Our Ref: P/40/22/NMA

**Section 96A of the Town & Country Planning Act 1990 (as amended)
Town and Country Planning (Development Management Procedure) (England) Order 2015
(as amended) - Article 10**

Non-material amendment following grant of P/70/19/RES to change some brick types on the Materials Schedule to some of the dwelling plots (Plots 51-52, 86-87 and 88-89) and replace rooflights to some plots to dormer windows (Plots 51-52, 86-87 and 88-89).

Land To The West Of Pagham Road Pagham PO21 4NG

|                                                                                                            |  |  |  | 1177-WD-411               |  |  |  |

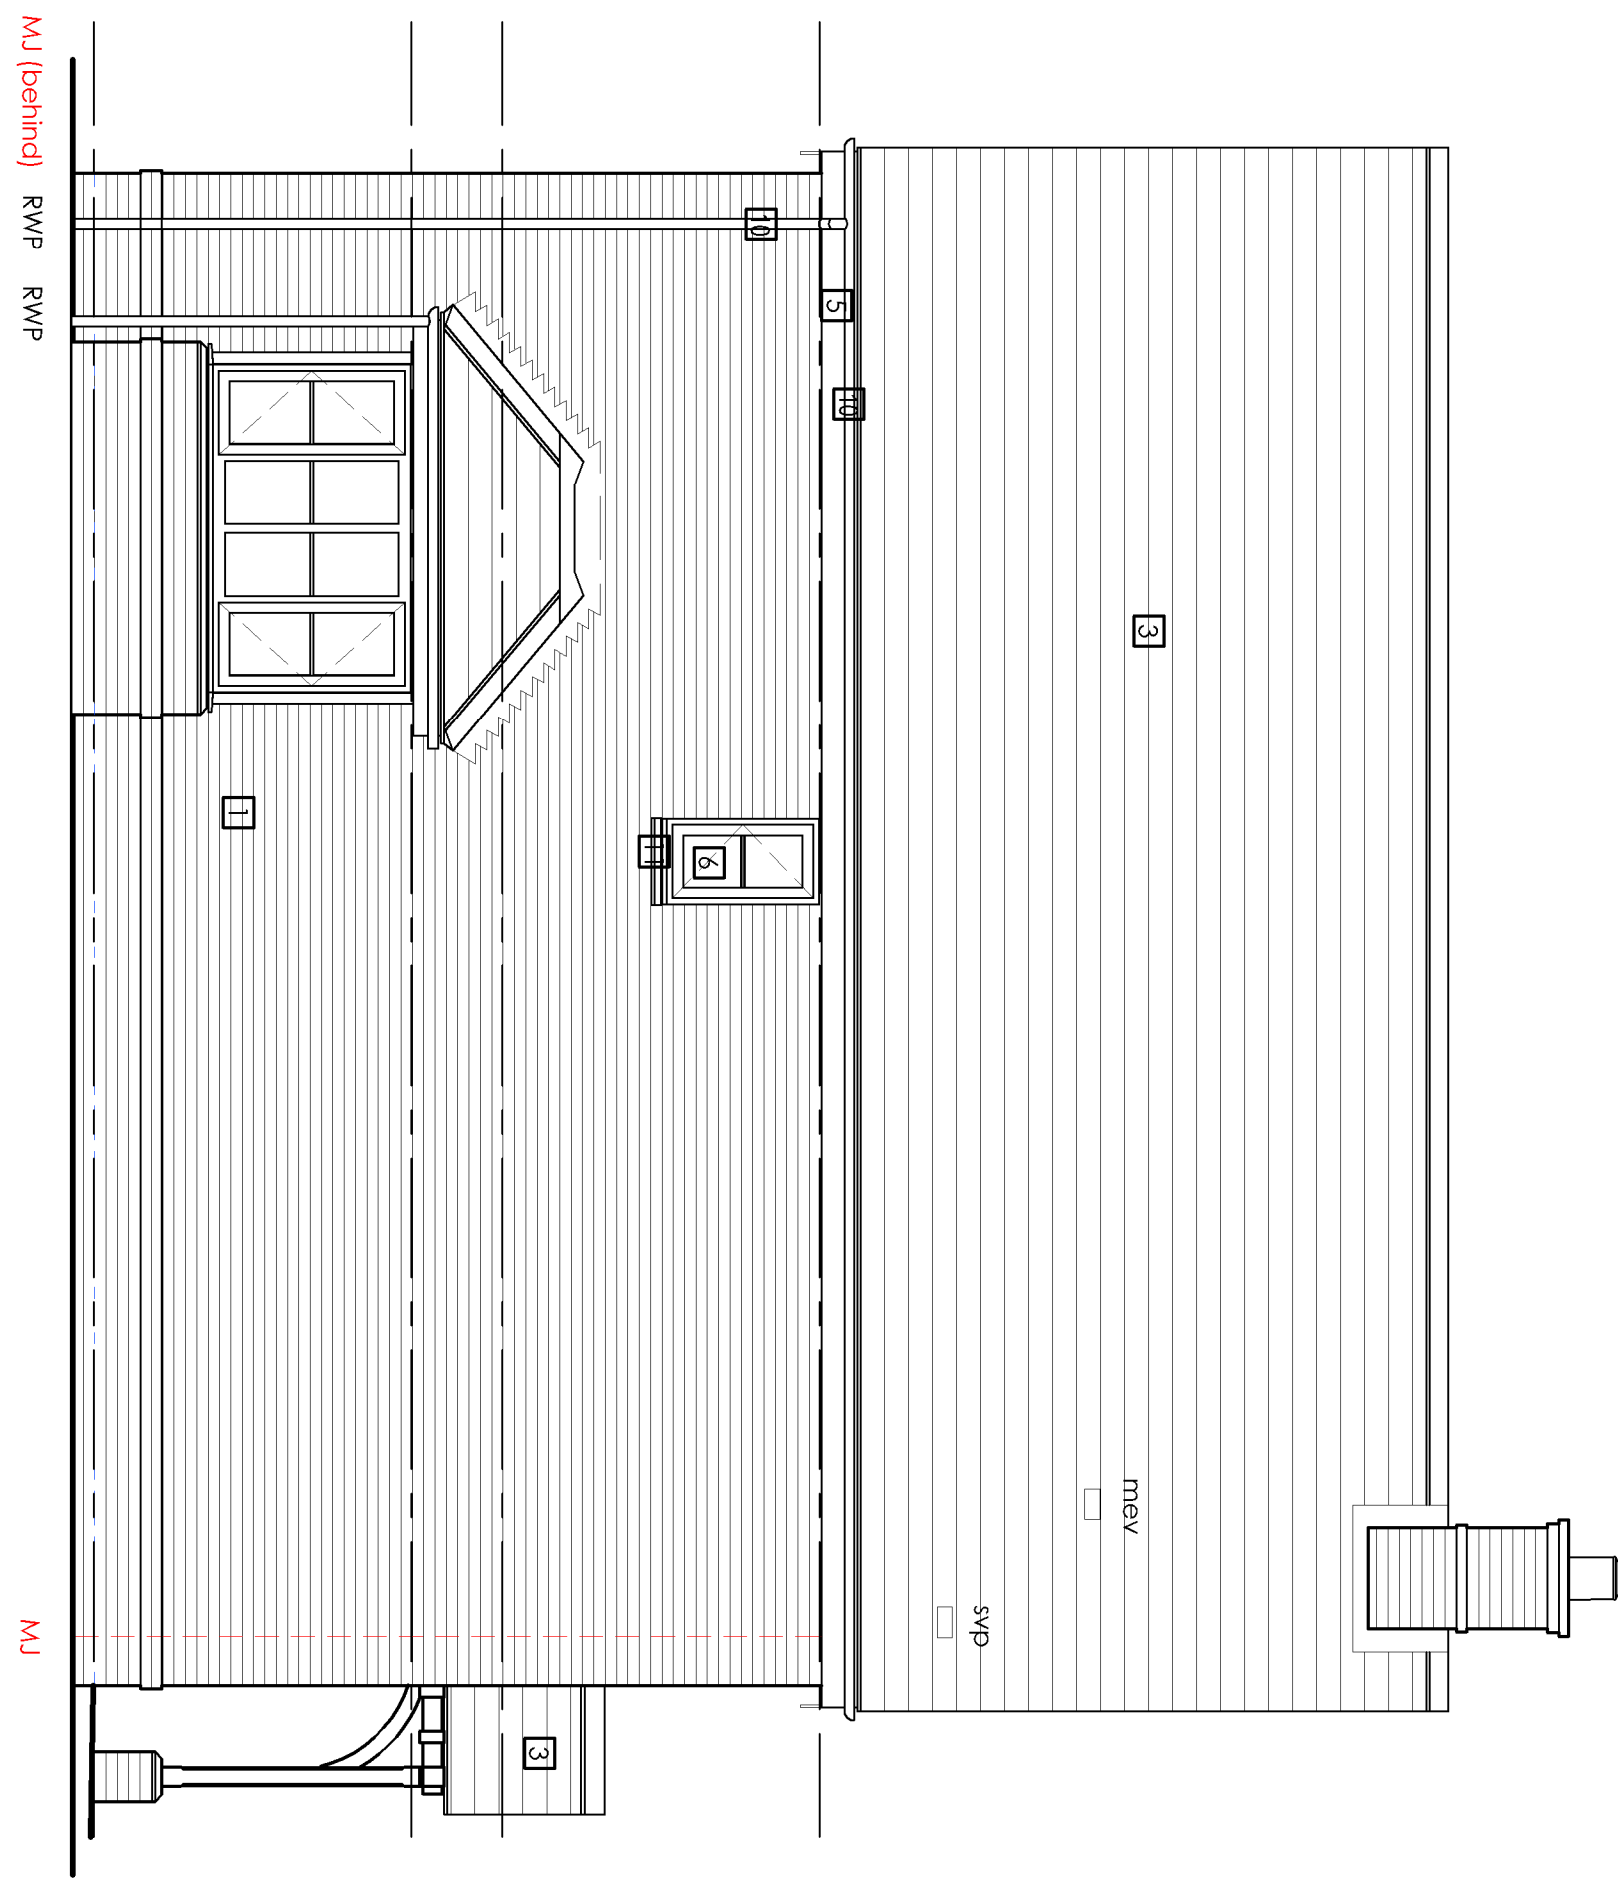
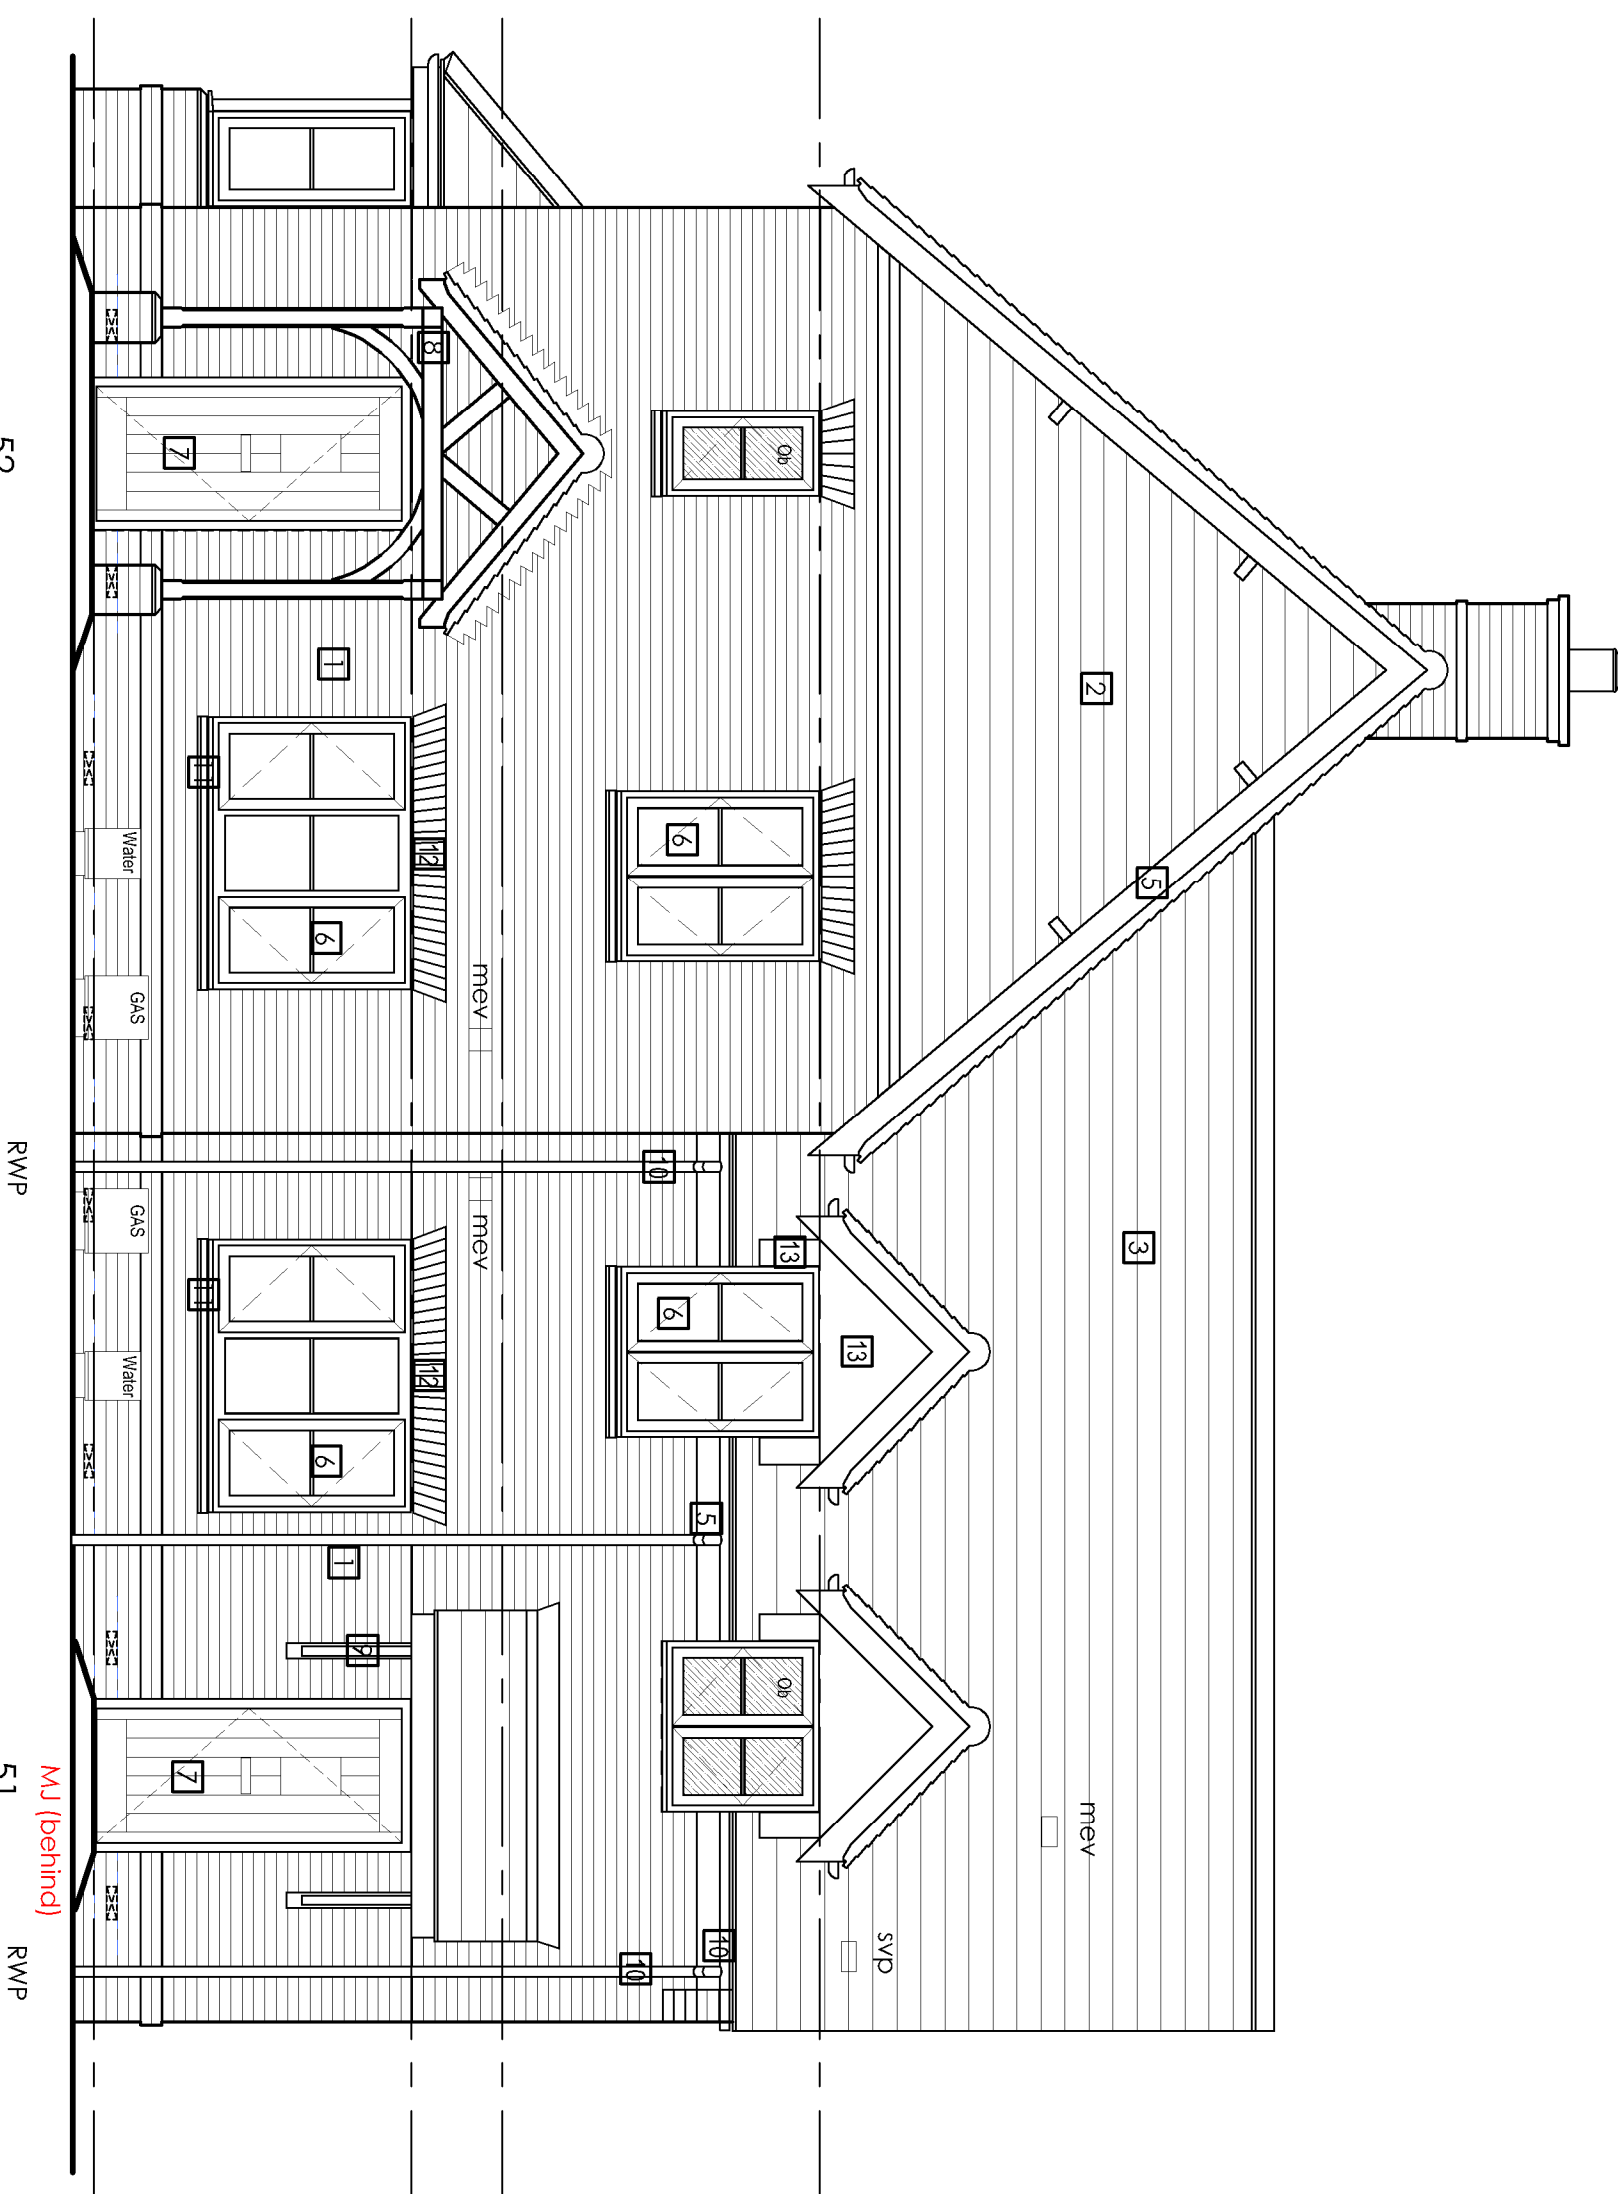
- use Ibstock Thakeham Red Multi Stock to some of the plots;
- use Vandersanden Sundridge Handmade Stock instead to some of the plots;
- replace roof lights on the fronts of the Hickstead house type (plots 51-52 & 86-89 only) with small dormers to match those already on the front and rear elevations.
